CITY OF PORTLAND, MAINE
PLANNING BOARD

June 10, 2008

RE: Portland Museum of Art Parking Lot, 87 Spring Street, Portland
CBL: 039 B015 001
Application ID: 2008-0038

Drawing file: Submissions / L2.1Photmetric rec's 5.21.08 & for Hearing.pdf

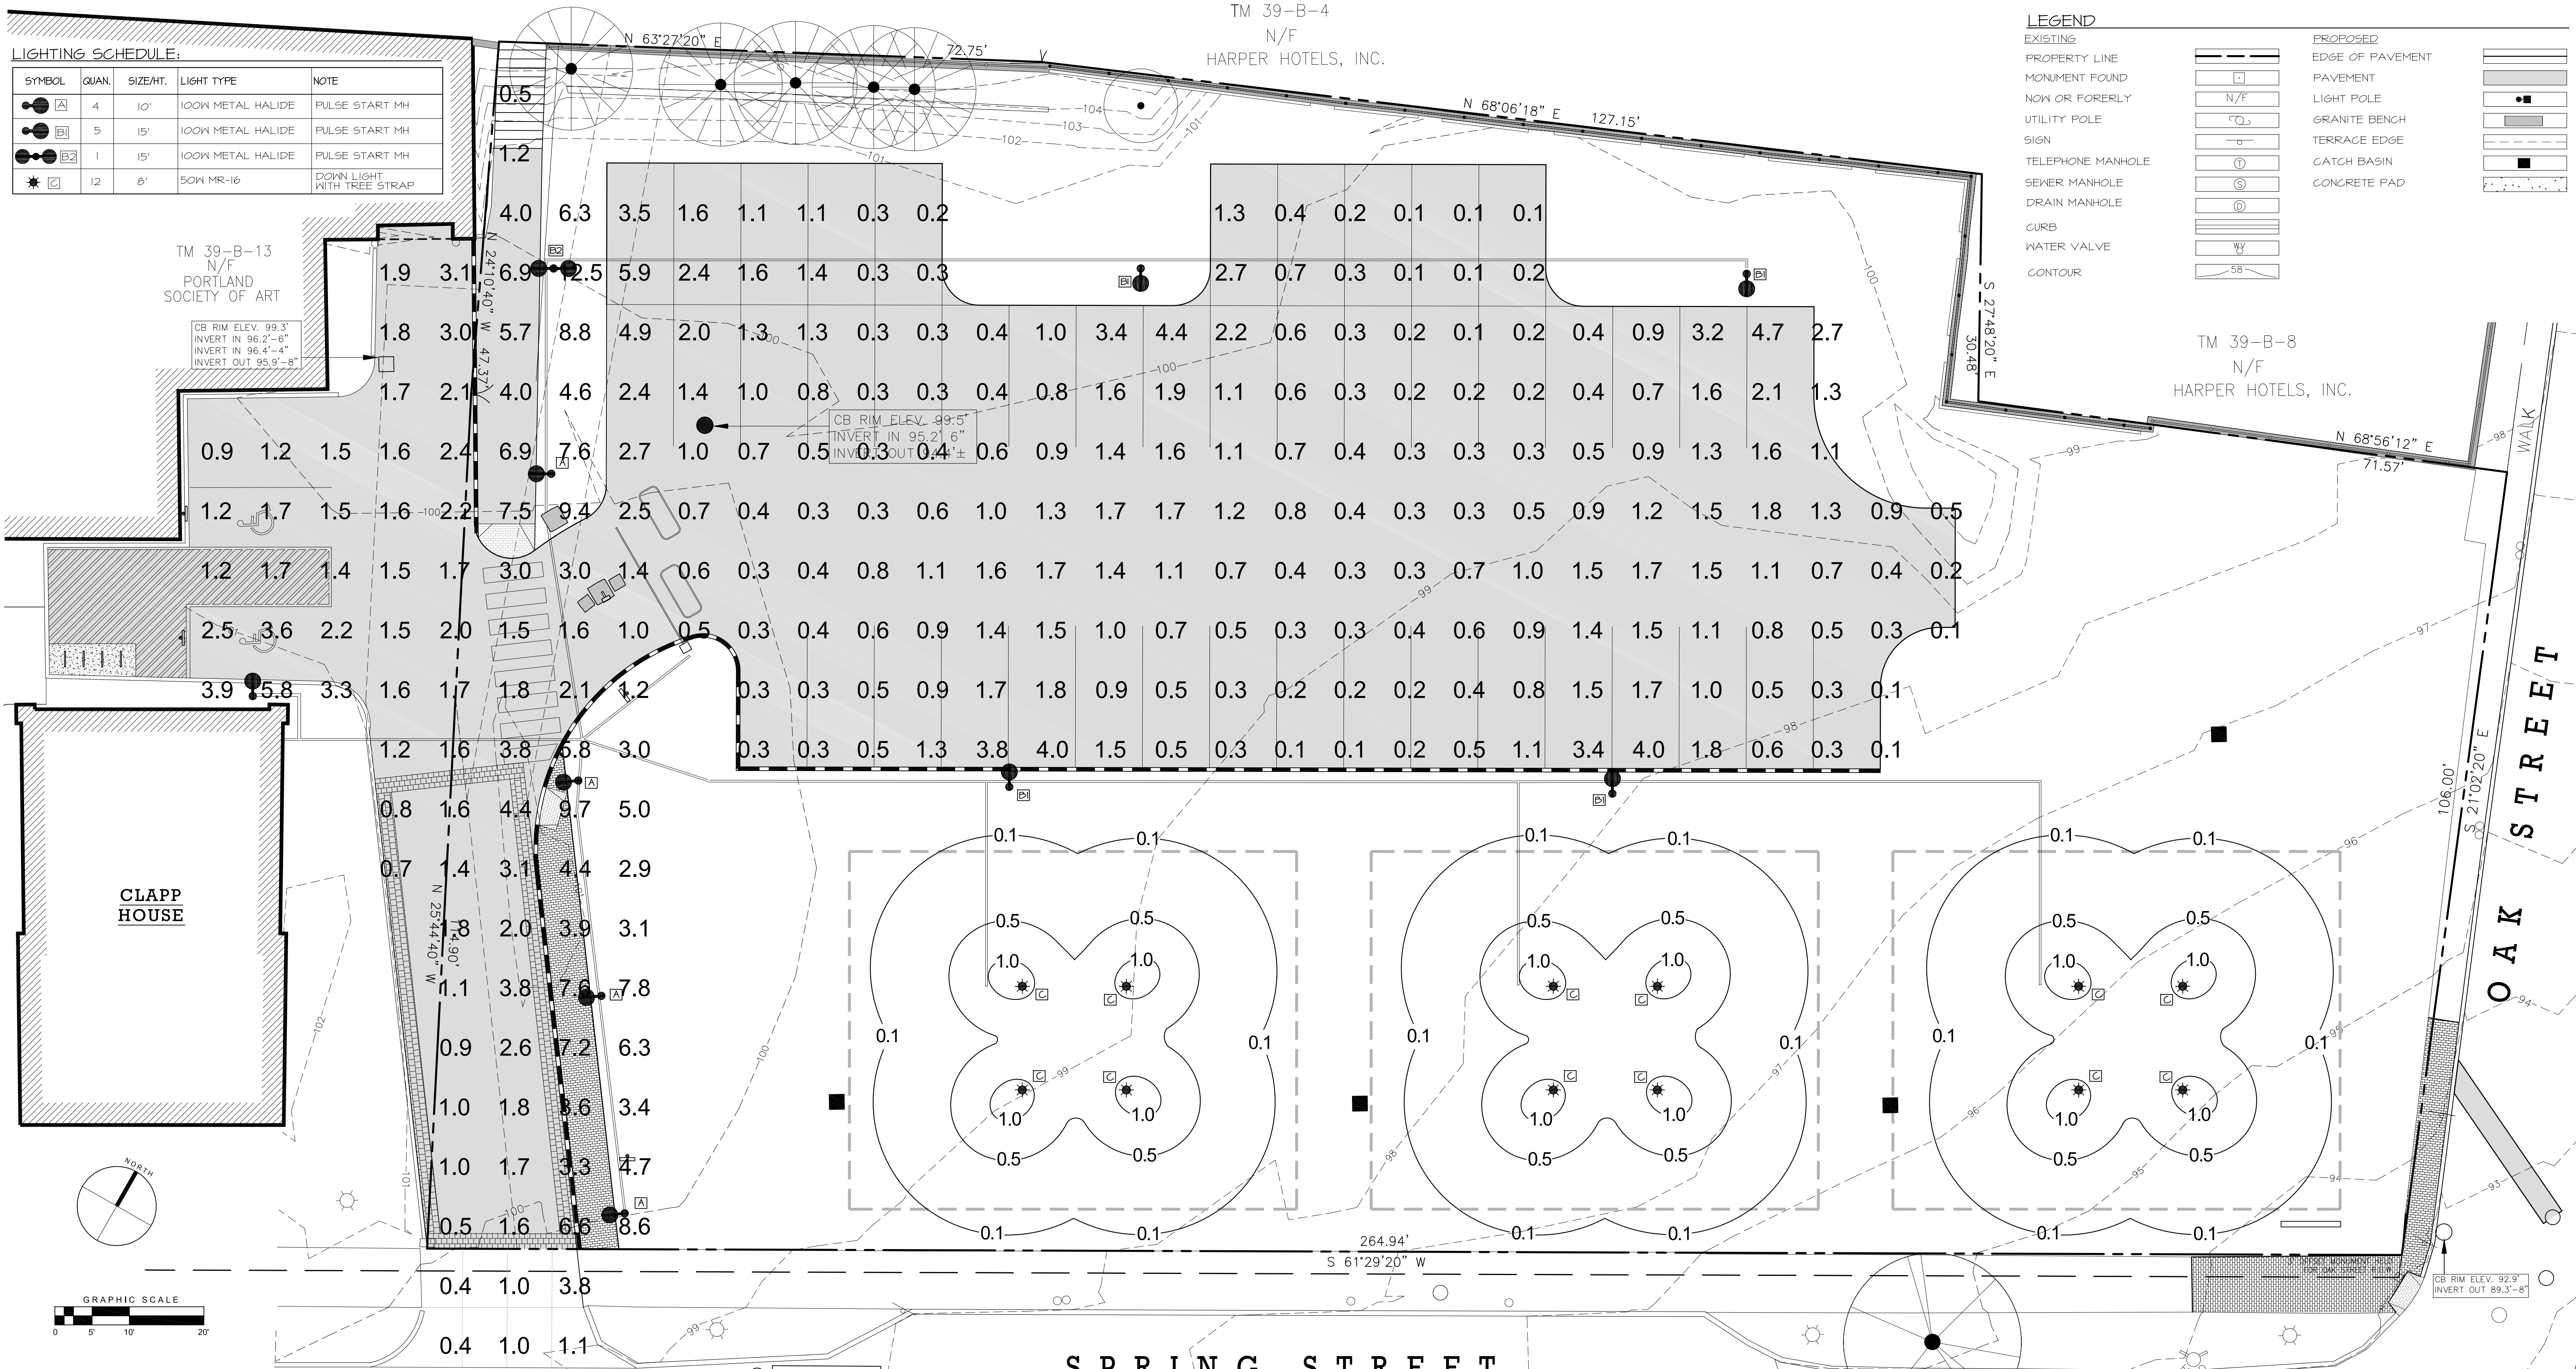
- iii. That the applicant shall submit revised proposals for the lighting along the pedestrian walkway through the site, which meet the City's Site Lighting Standards, for review and approval of the Planning Authority prior to the issuance of a building permit; and

**9 PMA IDENTIFICATION SIGN**  
L5.0 NOT TO SCALE

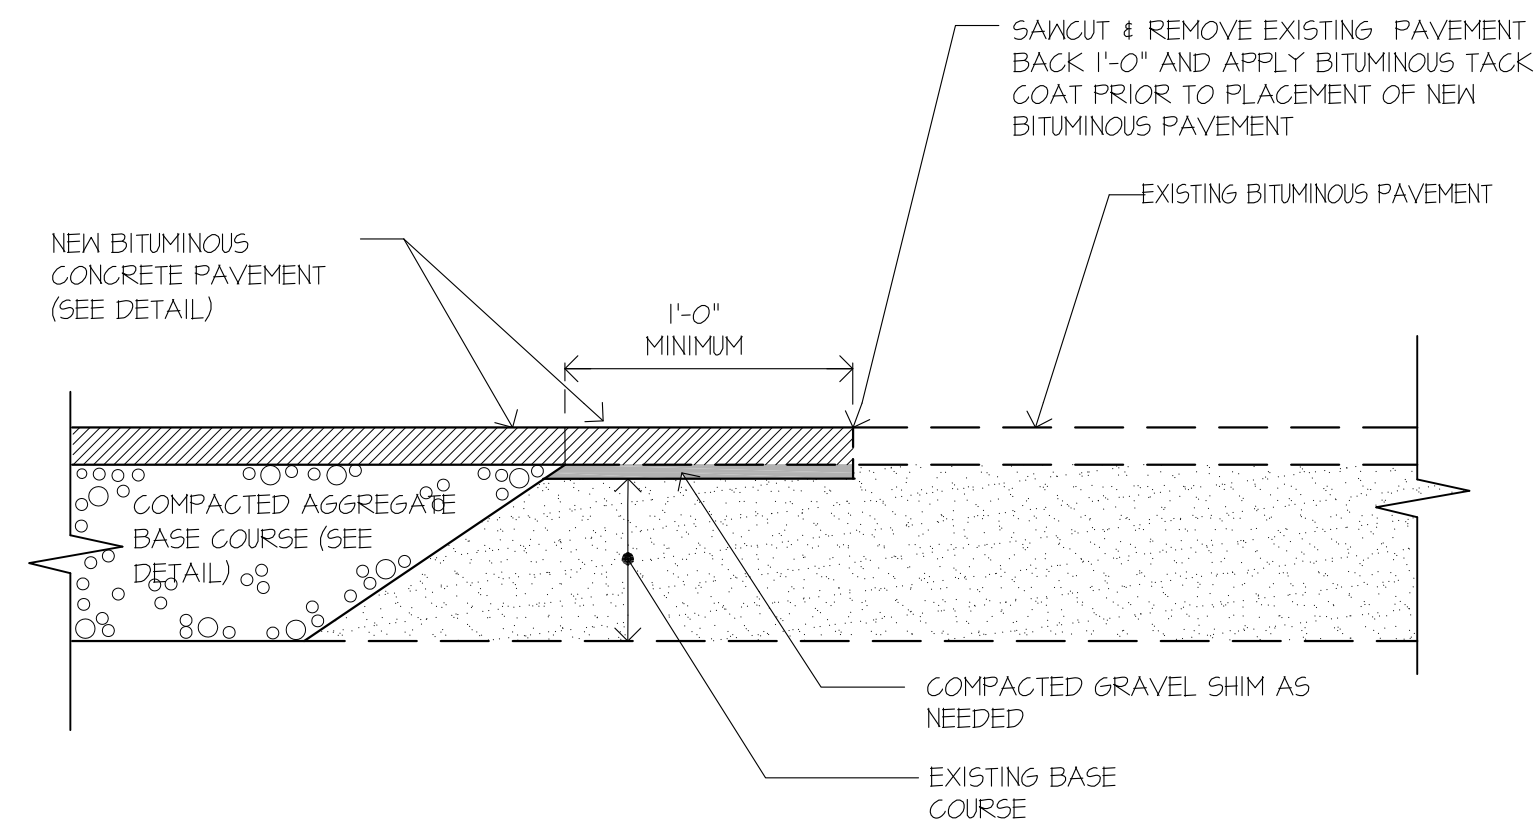
- iv. That any signs, including the proposed sign at the corner of Spring and Oak Streets shown in Plan 5.0, shall be subject to detailed review and approval prior to the issuance of a Certificate of Occupancy; and

1 FENCE AT CONCRETE RETAINING WALL AND STEEL TRELLIS (ALTERNATE #1): WEST SECTION  
 L5.3 SCALE: 1" = 4'

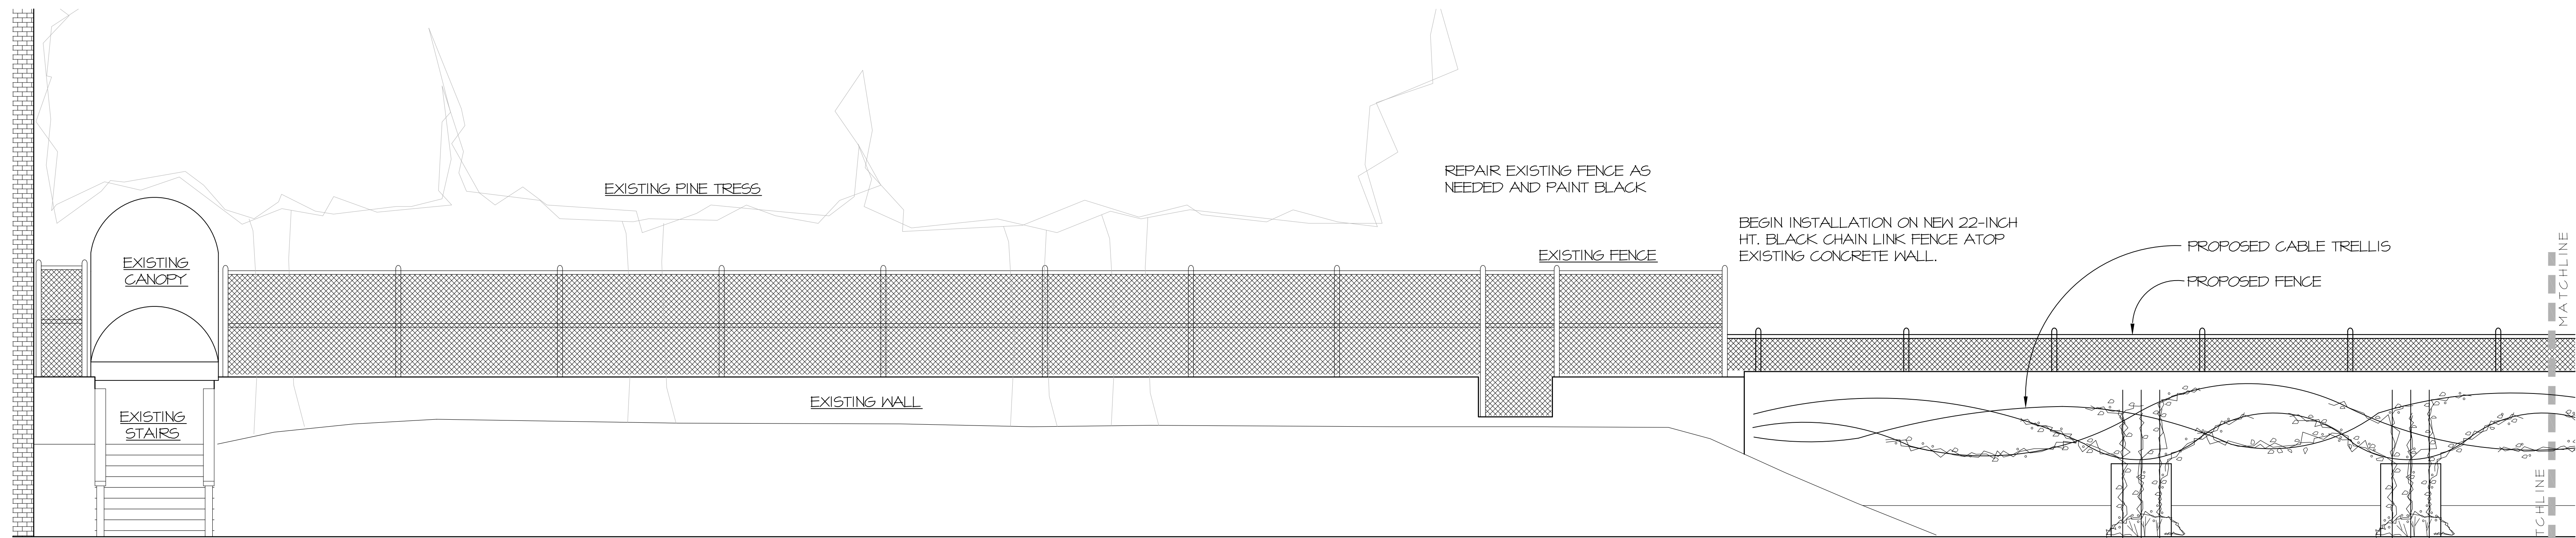
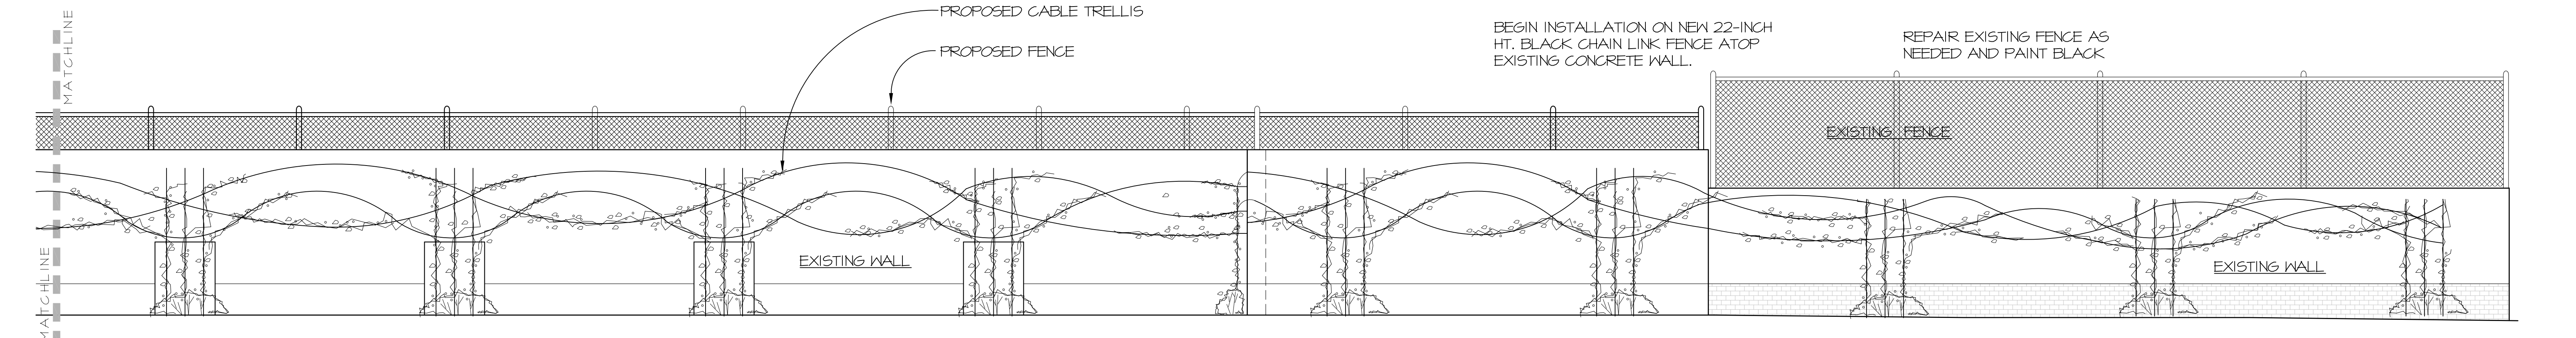
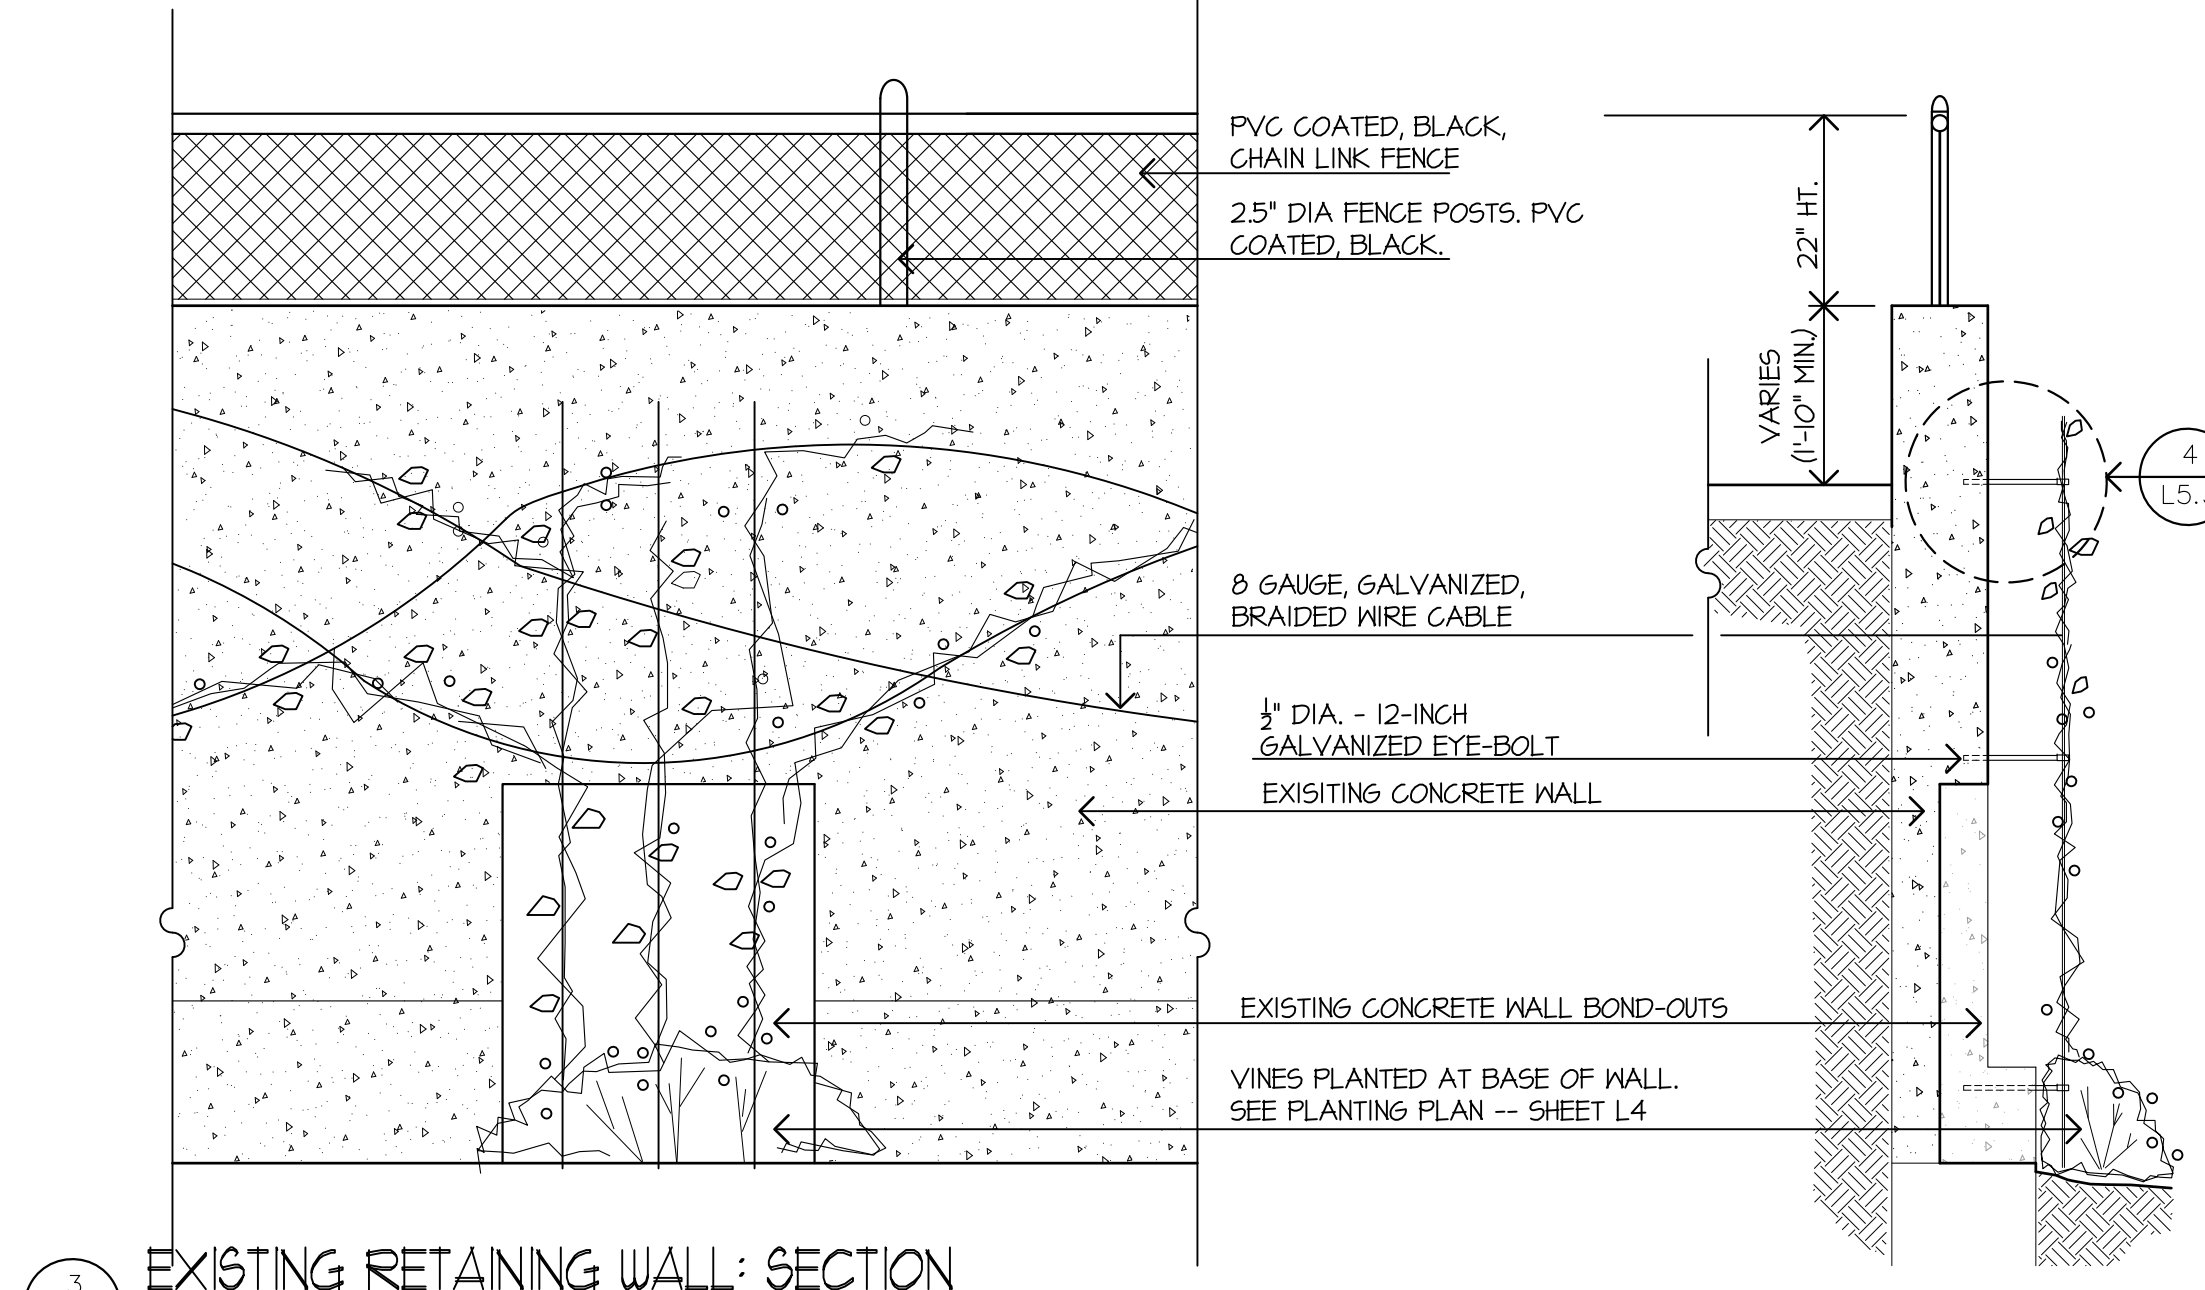
- v. That the applicant shall revise the design of the central portion of the fencing along the top of the existing retaining wall to address the concerns of the Children's Museum of Maine, to be submitted for review and approval by the Planning Authority prior to the issuance of a building permit.
